Permit **950218**

RE: 231 Park Avenue

Your application to erect a 3-D Sign 160 Sq.Ft. has been reviewed and a permit is herewith subject to the following requirements: This permit does not excuse the applicant from meeting applicable State and Federal laws.

Seadog Slinger  
3-D sculpt  
for sign rough -  
for sculpting

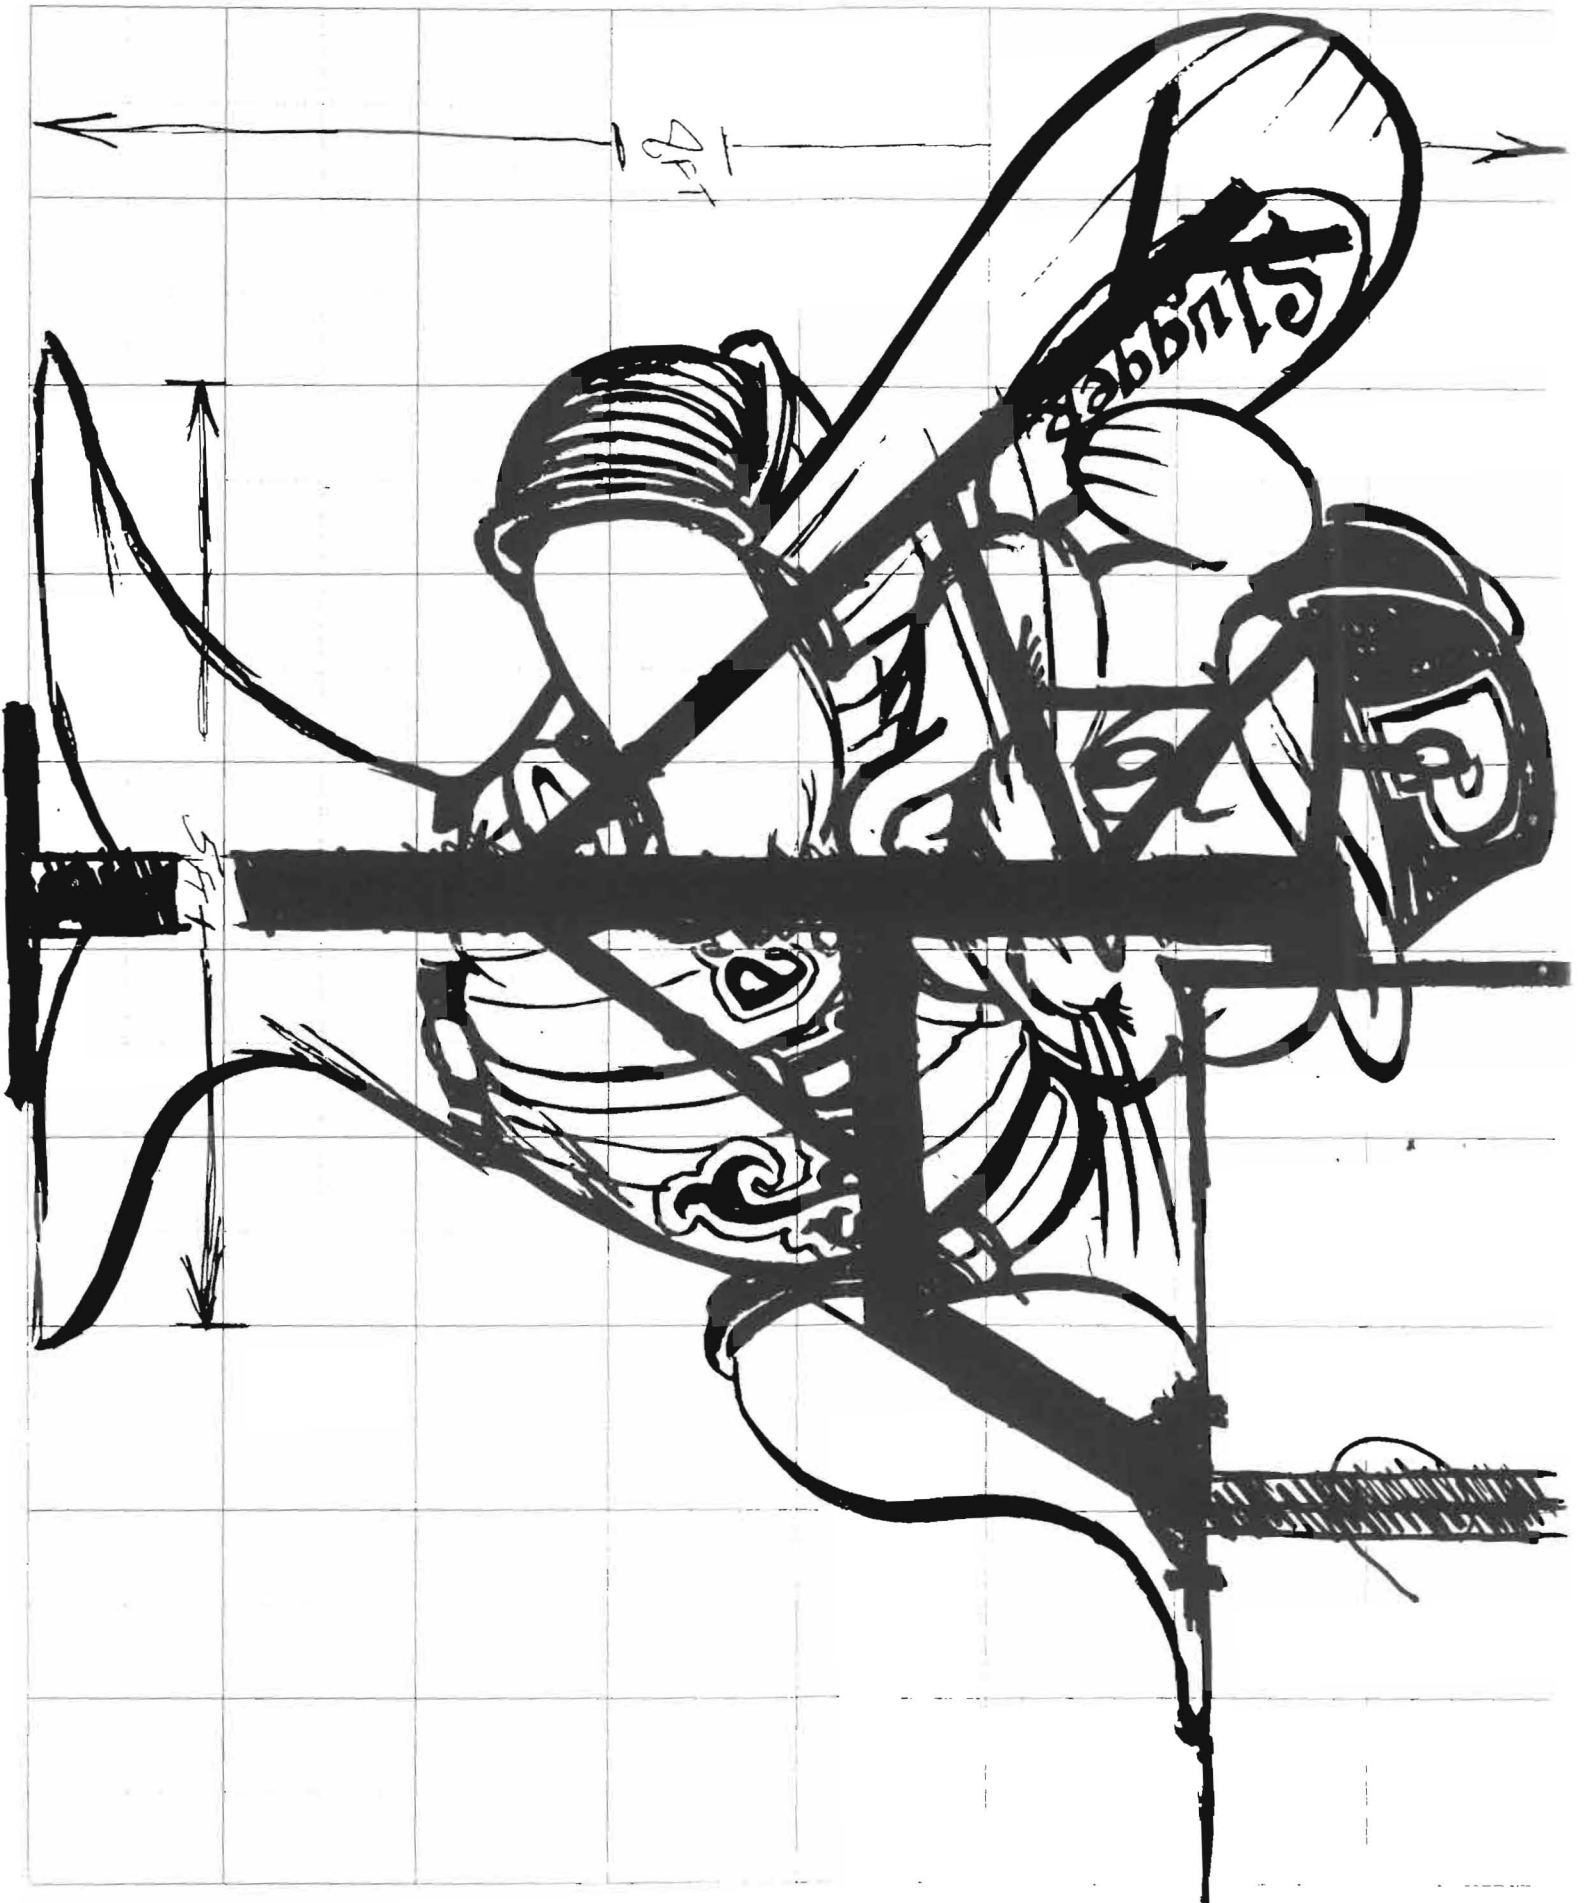
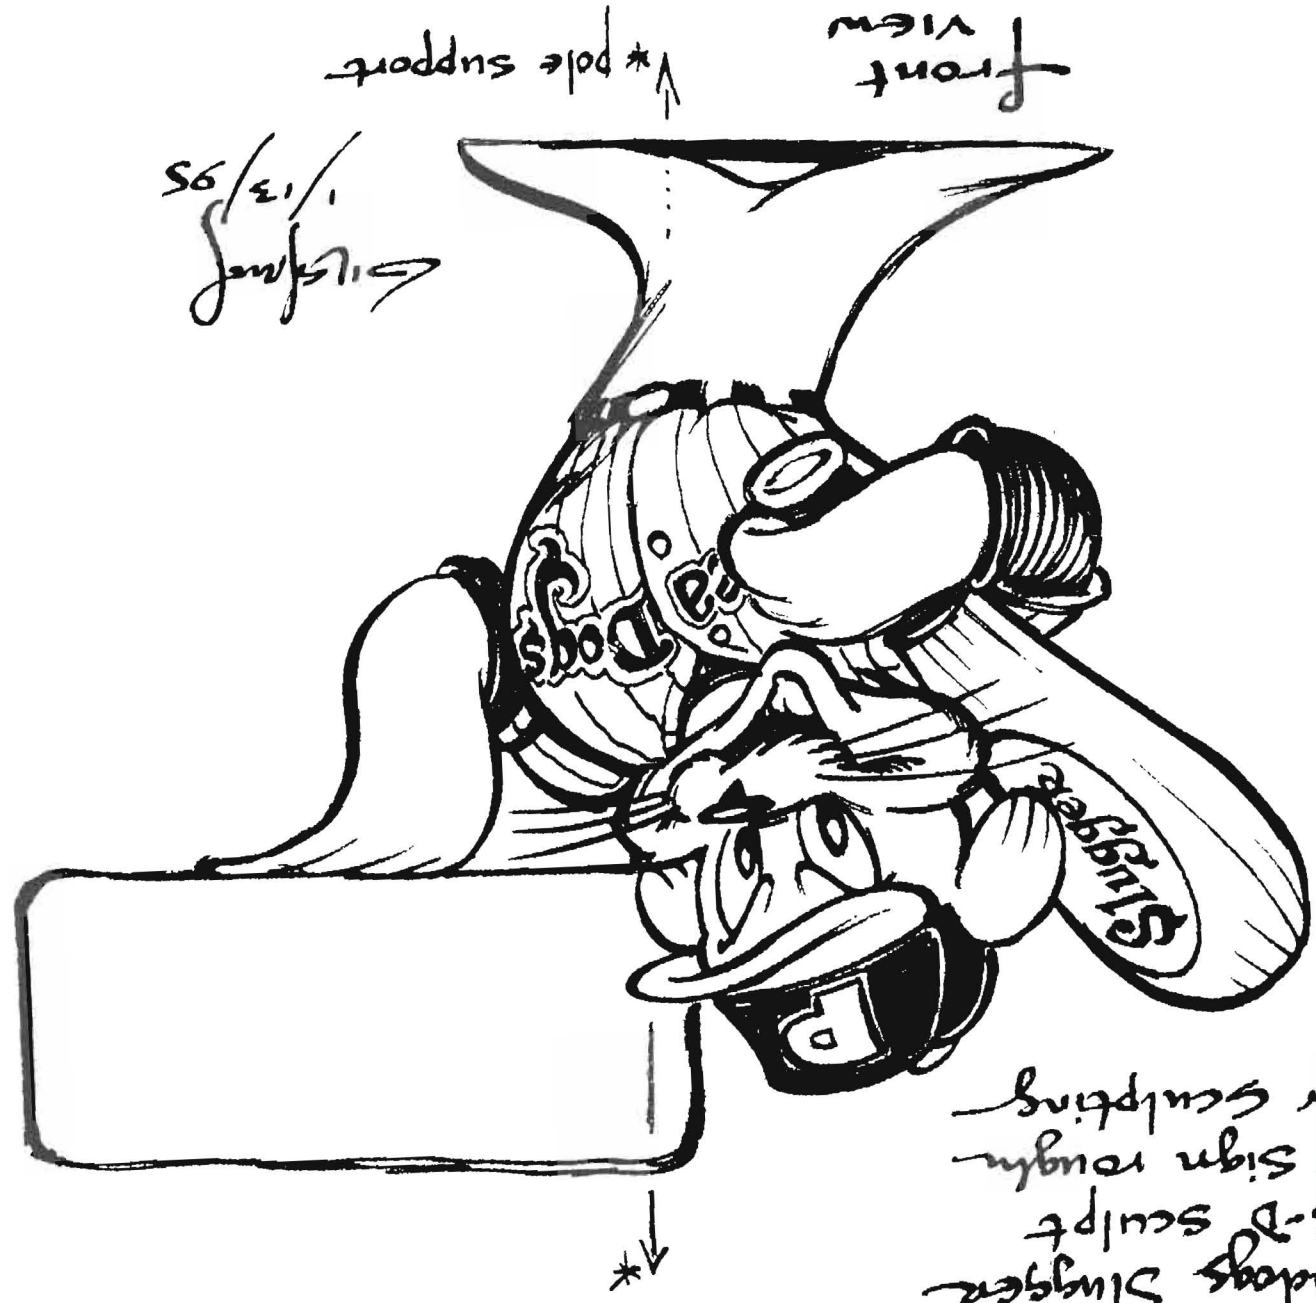
1. The base to be round constructed in granite and extend no higher than 8" above grade.
2. The final placement to be reviewed and approved by planning staff
